CITY OF ALBUQUERQUE

**RE: Lot 7, Block 11 Volcano Cliffs Unit 18
6524 Petirrojo Rd NW
Grading and Drainage Plan
Engineer's Stamp Date 4-20-16 (D10D003H6)**

Rita Harmon, P.E.
Senior Engineer, Hydrology
Planning Department

ENGINEER'S SEAL 4/20/16 DAVID SOULE P.E. #14522	LOT 7, BLOCK 11, UNIT 18 VOLCANO CLIFFS SUBDIVISION	DRAWN BY JDG DATE 04-21-2016
	GRADING AND DRAINAGE PLAN	SHEET # 1 OF 1
 Ro Grande Engineering 1606 CENTRAL AVENUE SE SUITE 201 ALBUQUERQUE, NM 87106 (505) 872-0989		JOB #

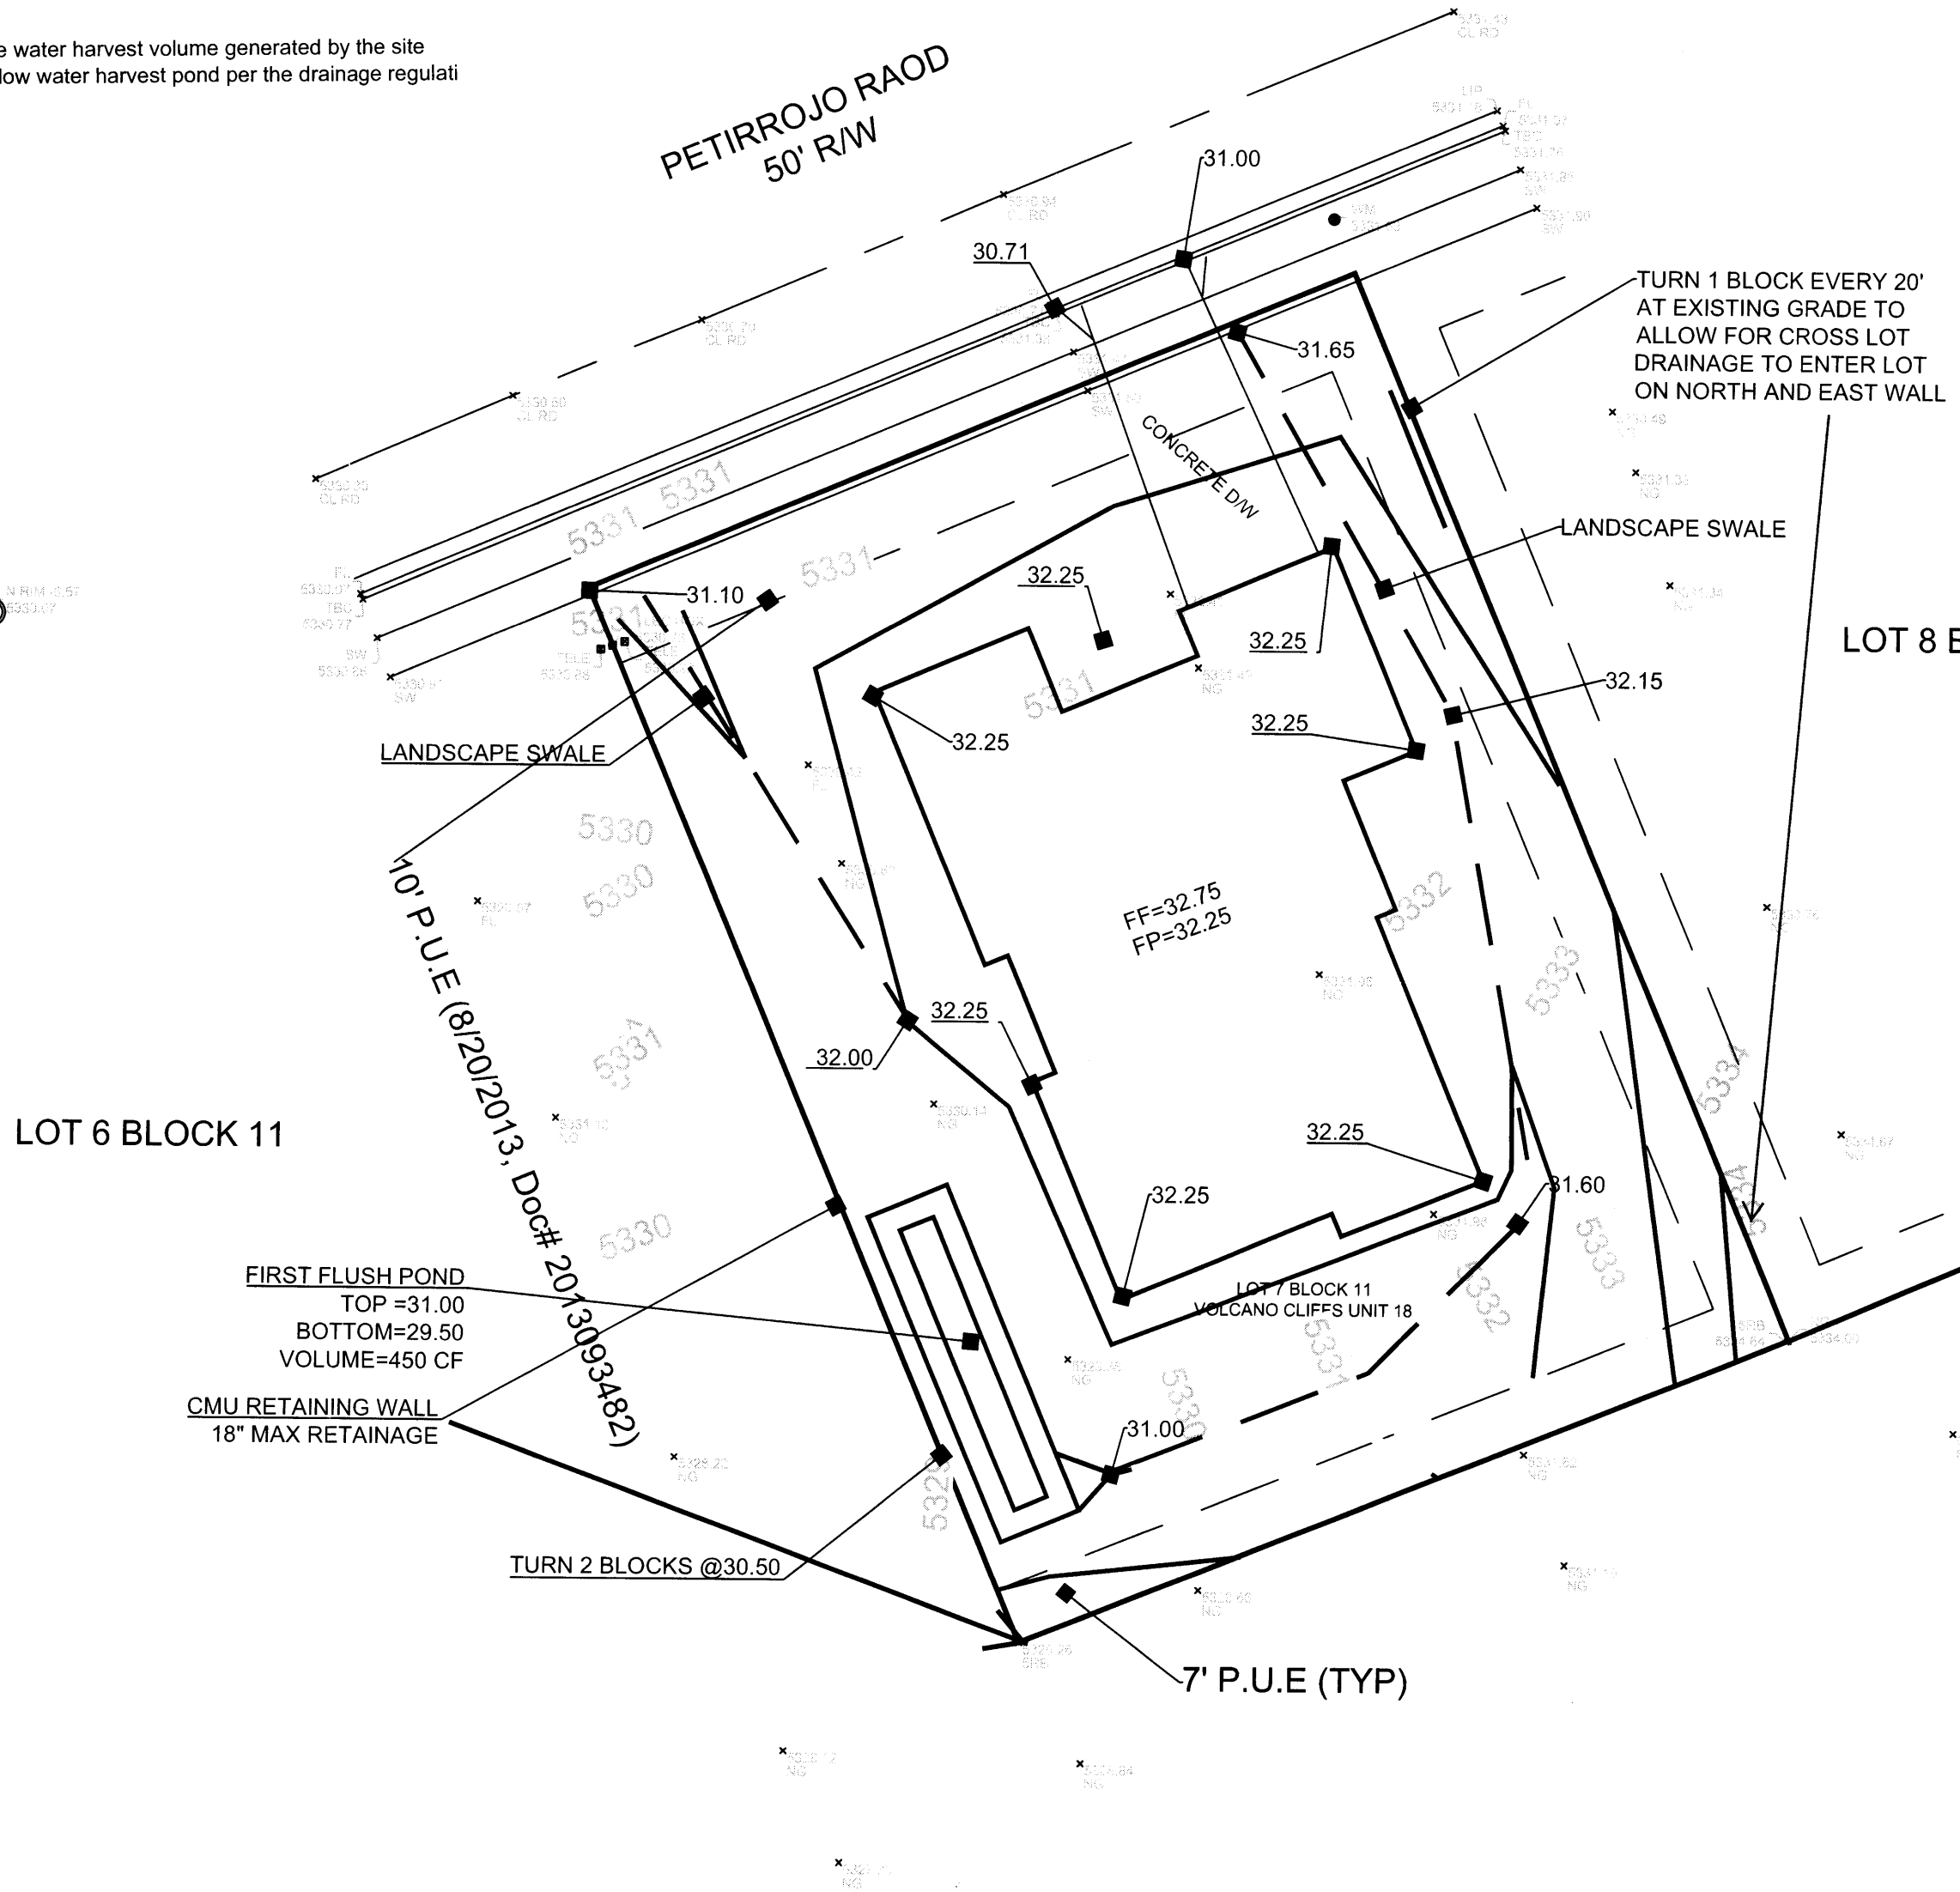
Please attach a copy of this approved plan to the construction sets in the permitting process prior to sign-off by Hydrology. A separate permit for the wall is required. Attach this approved plan to the wall permit set. Place all turn blocks 3" above grade for sediment control and landscaping.
